The proposal results in a substantial alteration to the property which is a key property within the Angmering Conservation Area.

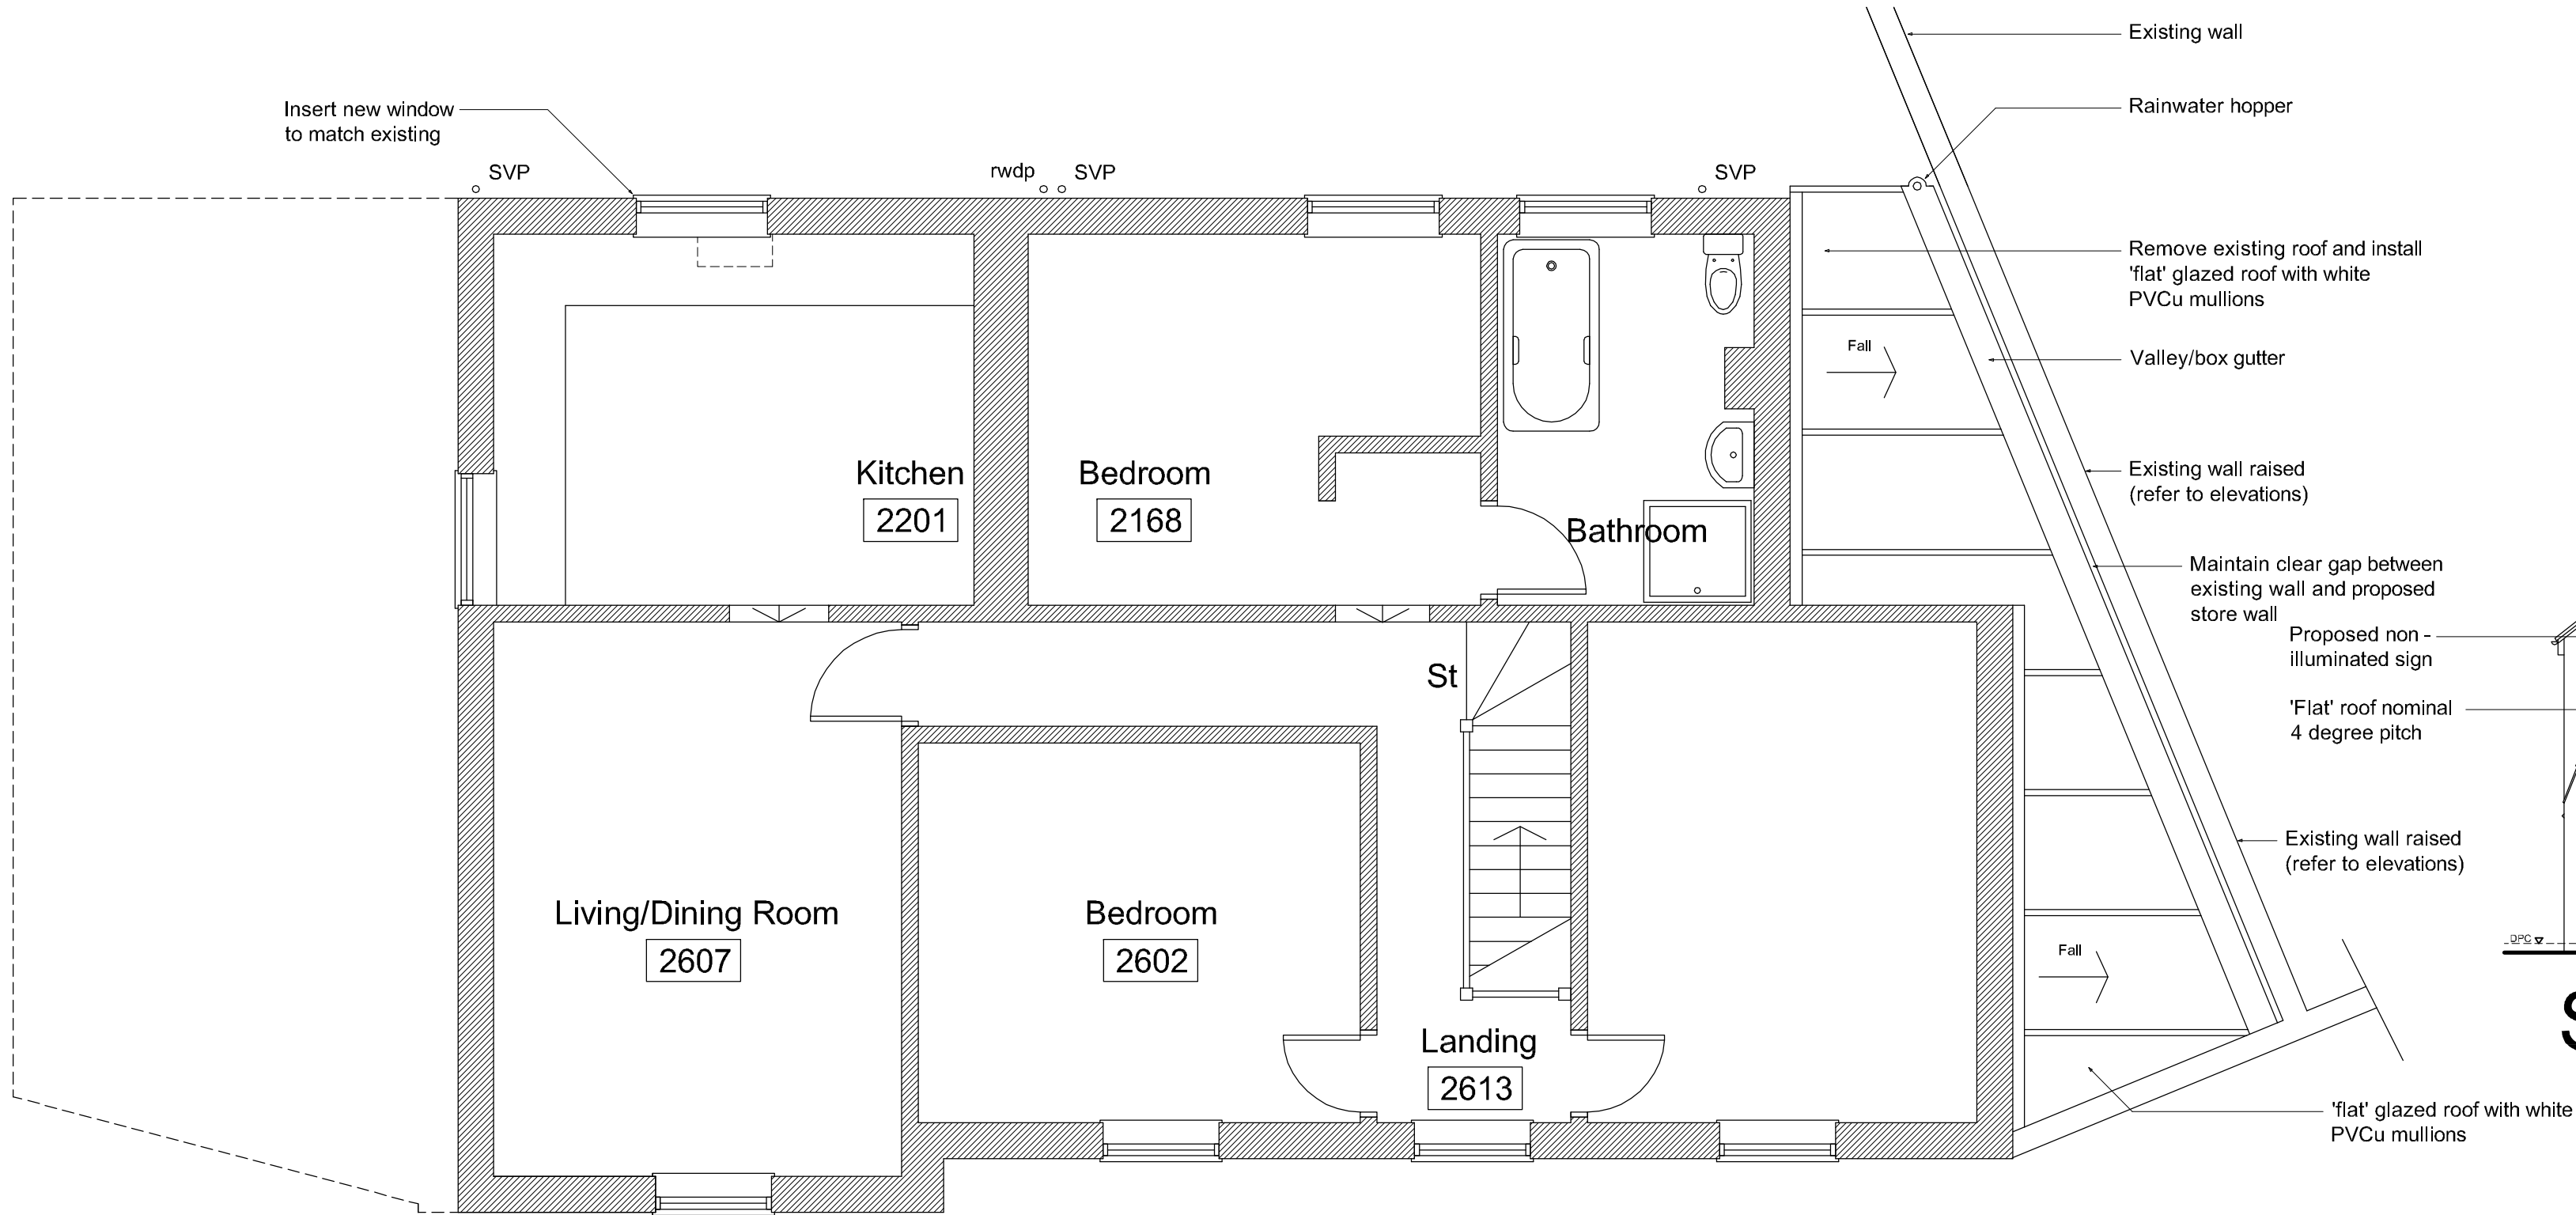
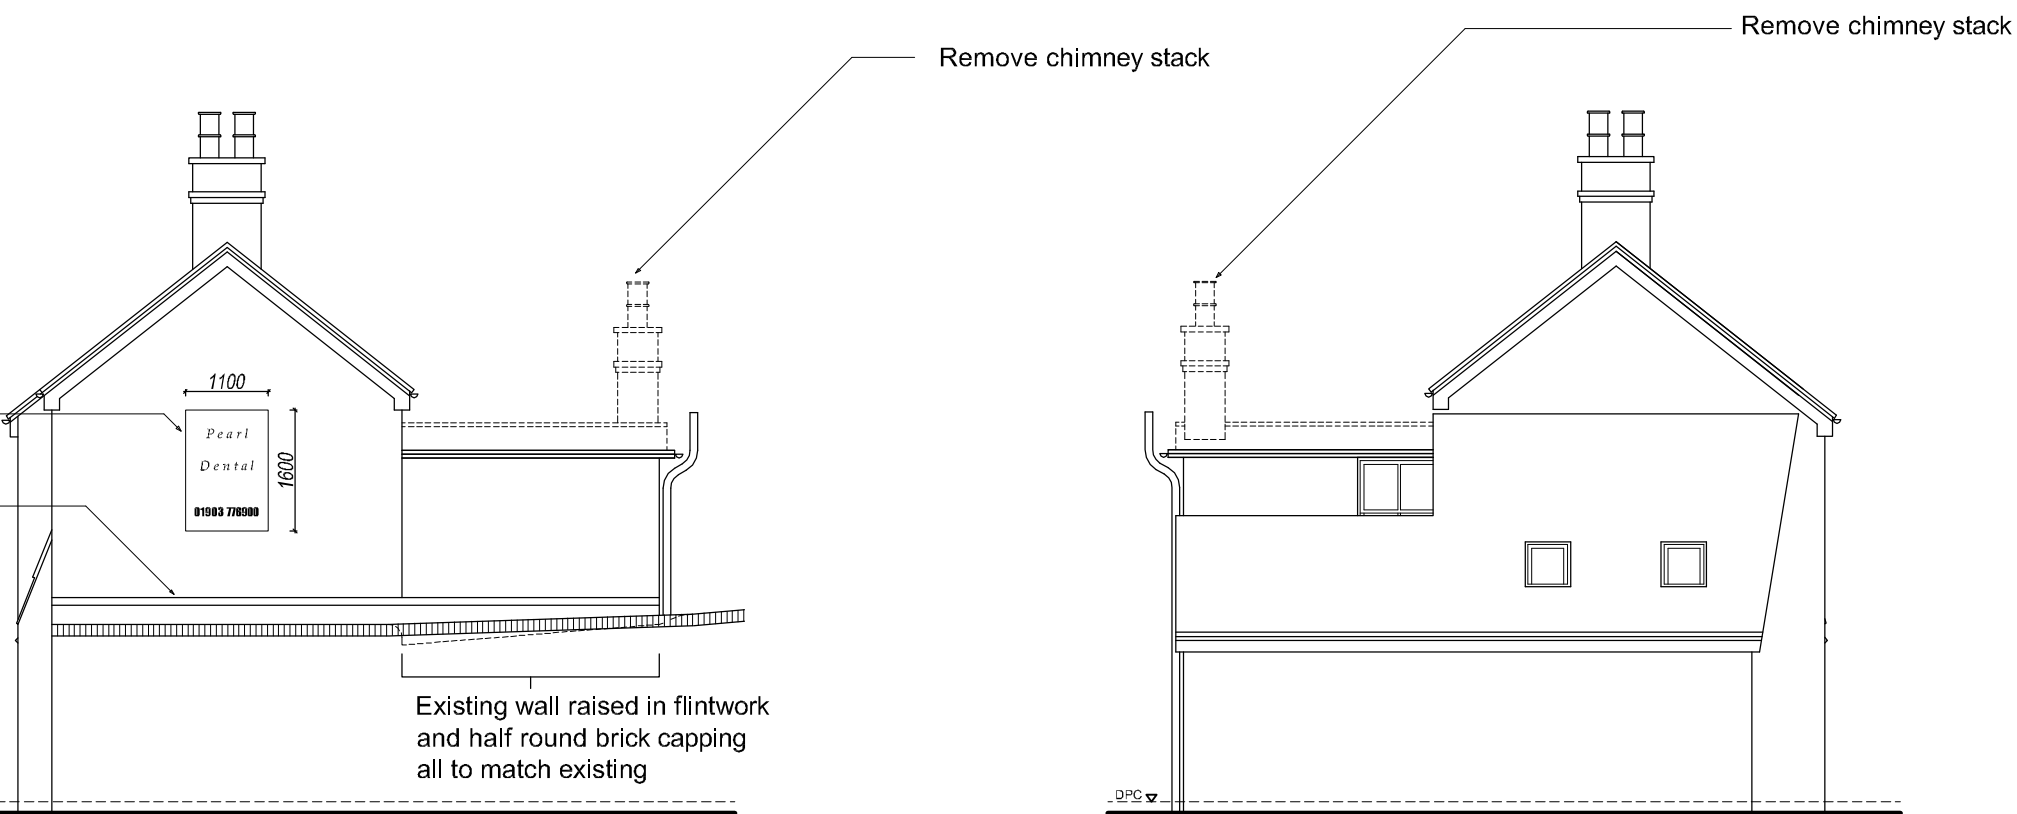
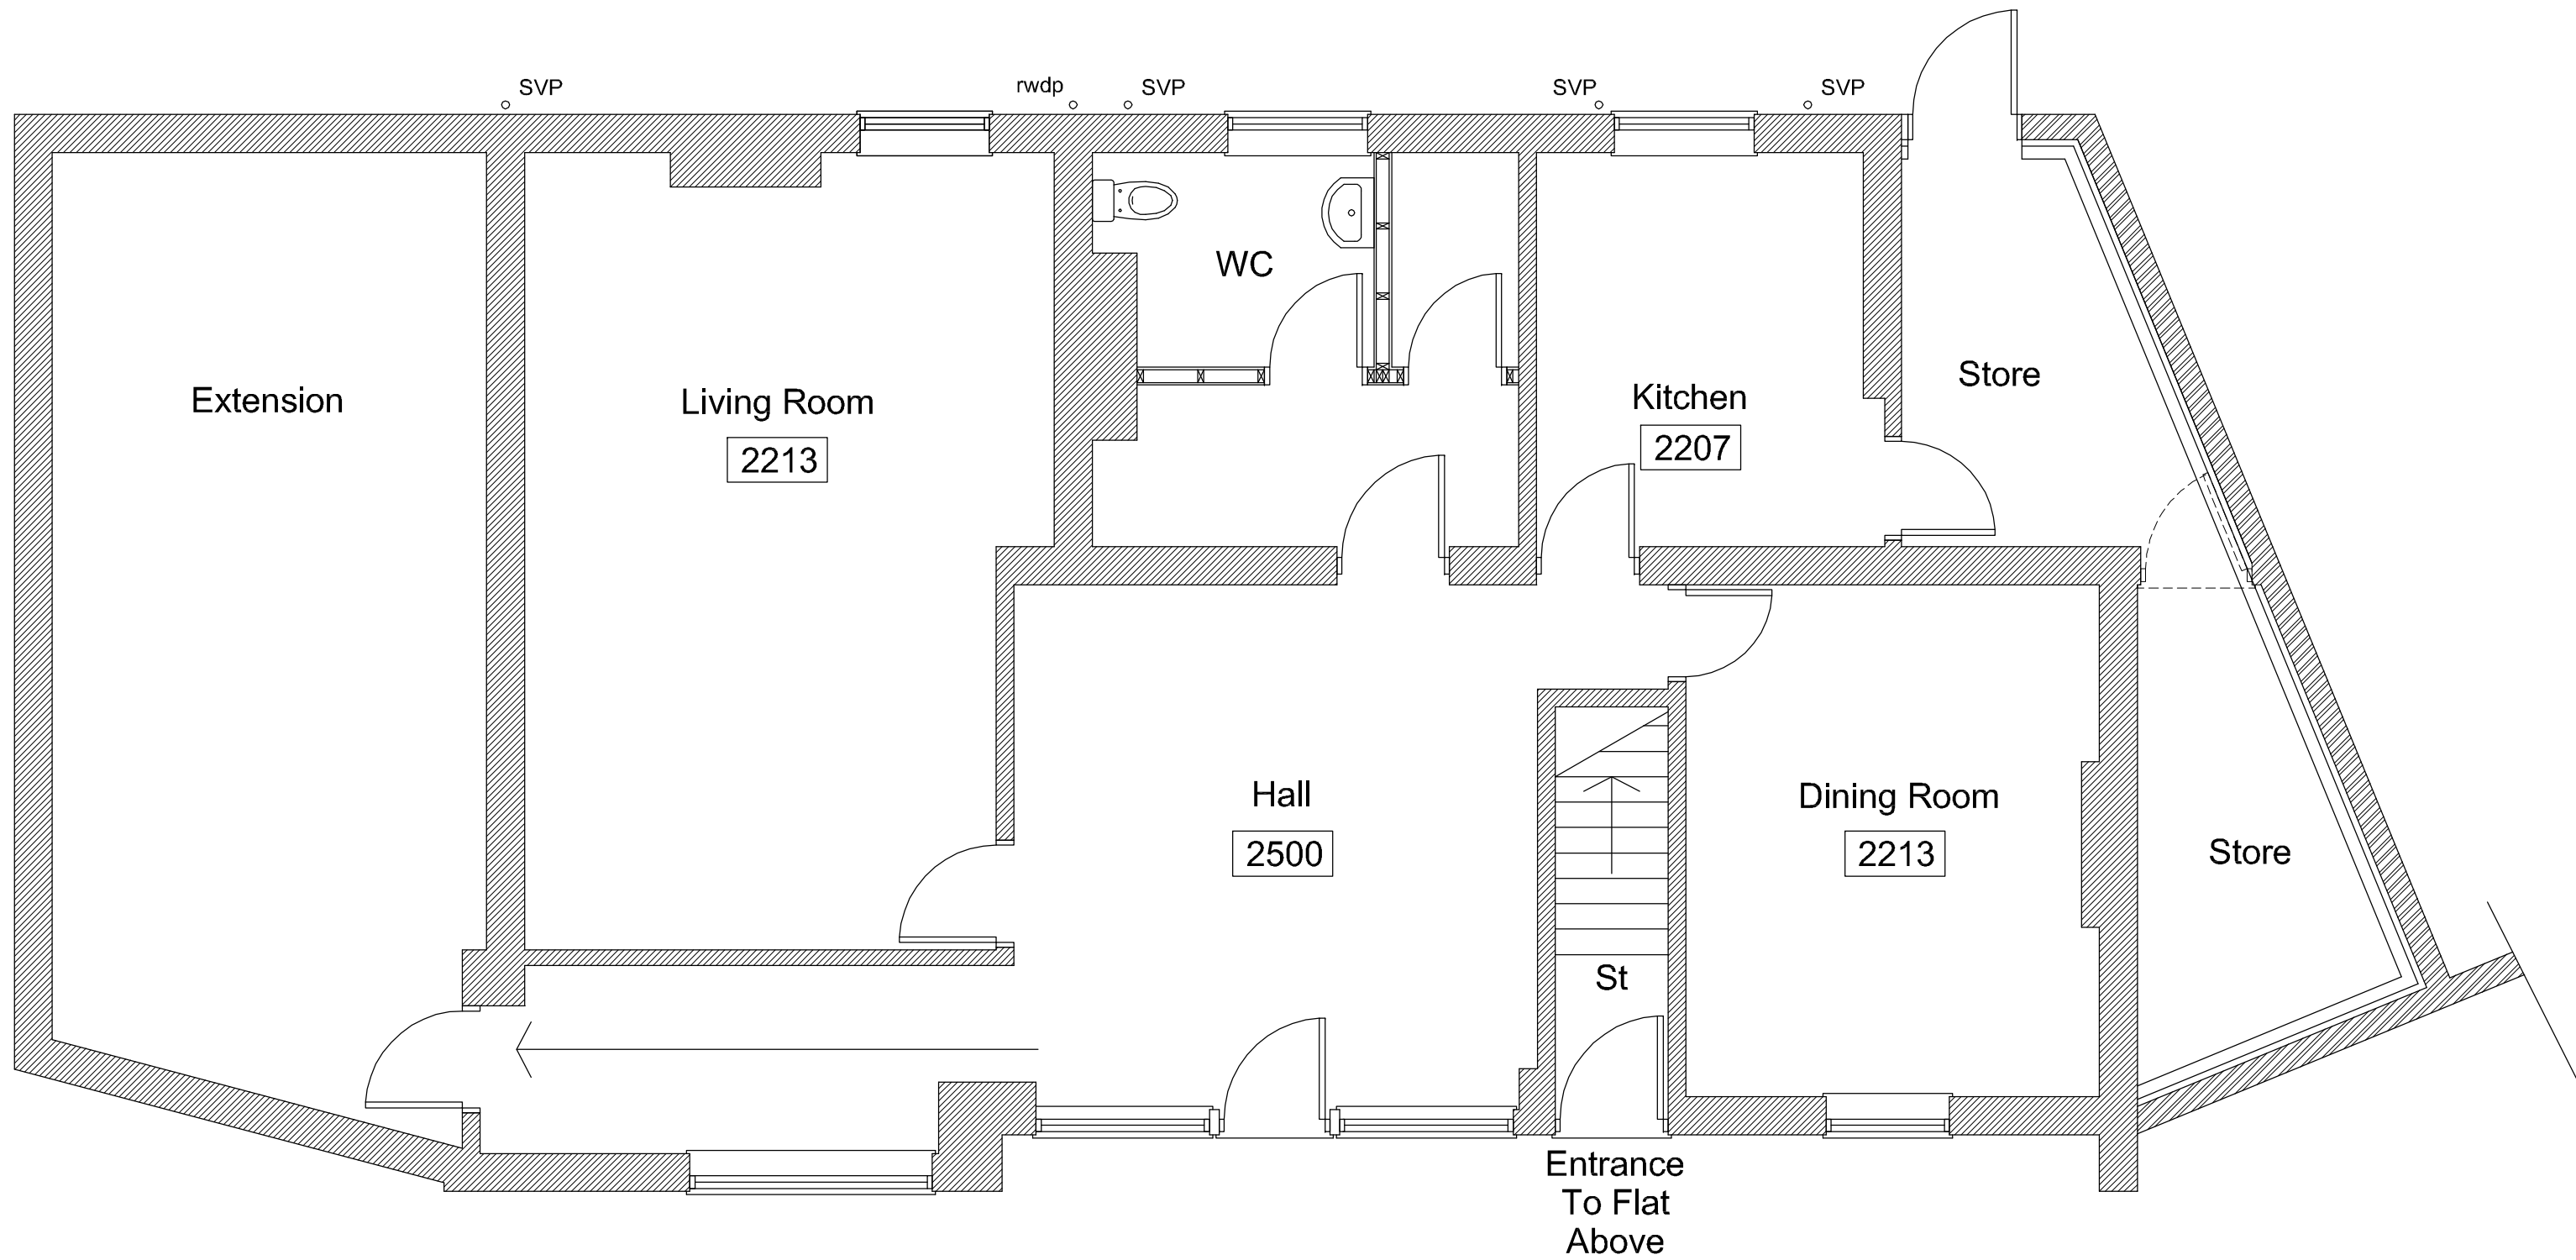
The shape, height and variety of chimney stacks and other architectural details on buildings in a conservation area such as this contribute greatly to the local character and should be retained and repaired. The removal of the chimney stacks (especially the main stack), would have a negative impact on the appearance of the property, and on the rest of the square. Such a loss cannot be supported.

Timber eaves, fascias and bargeboards can also contribute significantly to the character and appearance of the roof and should be retained and maintained. Looking at the pictures provided, it is clear that the proposal would lead to the loss of such features at the rear of the property. The loss of the roof plan would also be problematic, as it appears to be an original feature of the property. Can an alternative option be considered which would retain more historic fabric/appearance?

- Removal of a section of roofing and its replacement with a flat roof to the side of the property:
- Can it be confirmed if the replacement/new flat roof would be visible from the front elevation. At the moment, the side elevation appears to identify that the flat roof would appear above the of the front walling

WE PROPOSE TO REMOVE THE REAR STACK ONLY

WE PROPOSE A WELL DETAILED LEAD FLAT ROOF WITH STANDING ROLLED SEAMS AND TIMBER PAINTED FASCIA BOARD. WE PROPOSES TO REPLACE ANY SLATES WITH SLATES TO MATCH AS NECESSARY.

YES, A SMALL PORTION OF ROOF WOULD BE SEEN FROM THE STREET (THE WEDGE SHAPED SIDE OF THE PROPOSED ROOF) HOWEVER THIS COULD BE DETAILED WITH A GLAZED TRIANGULAR PANEL OR WHITE PAINTED TIMBER PANEL TO THE STREETSCENE.
